CITY OF ALBUQUERQUE

February 10, 2020

Re: 3308 4th St. Apartments
3308 4th St. NW
Request for Certificate of Occupancy
Transportation Development Final Inspection
Engineer's/Architect's Stamp dated 6-14-18 (H14D109)
Certification dated 1-16-20

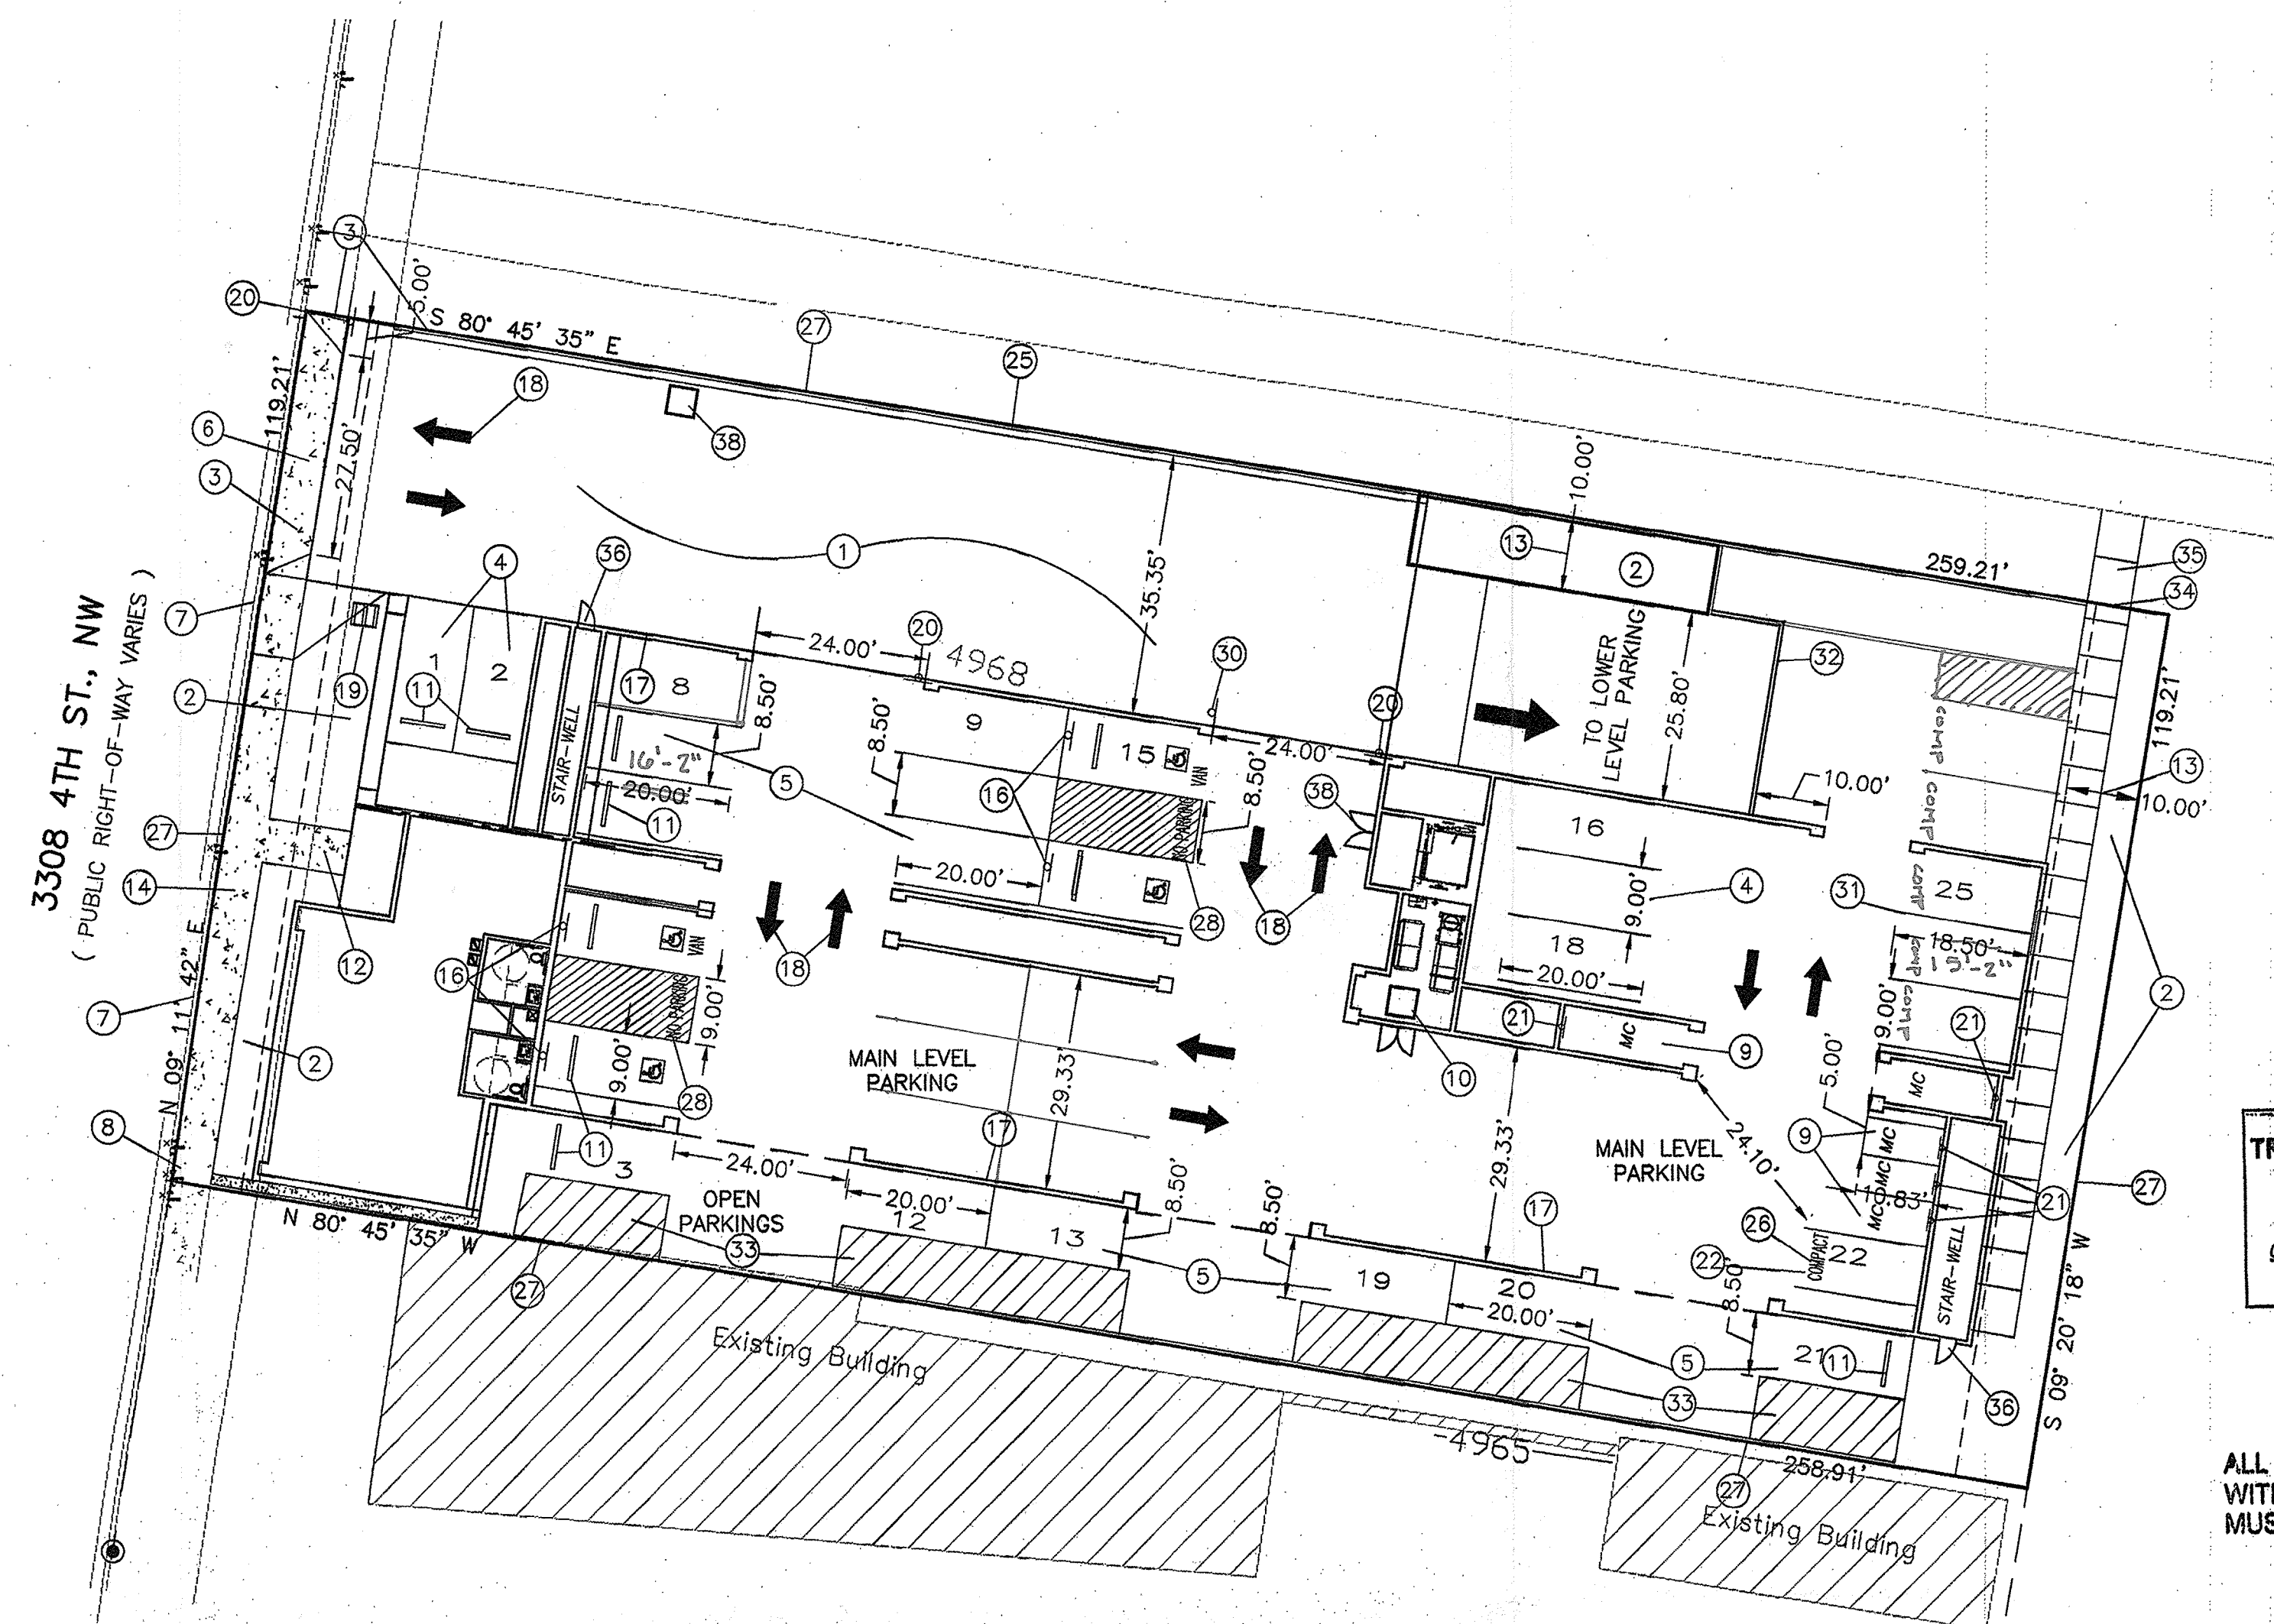
1. Lower level compact spaces may need to be angled to allow better maneuverability for backing out.
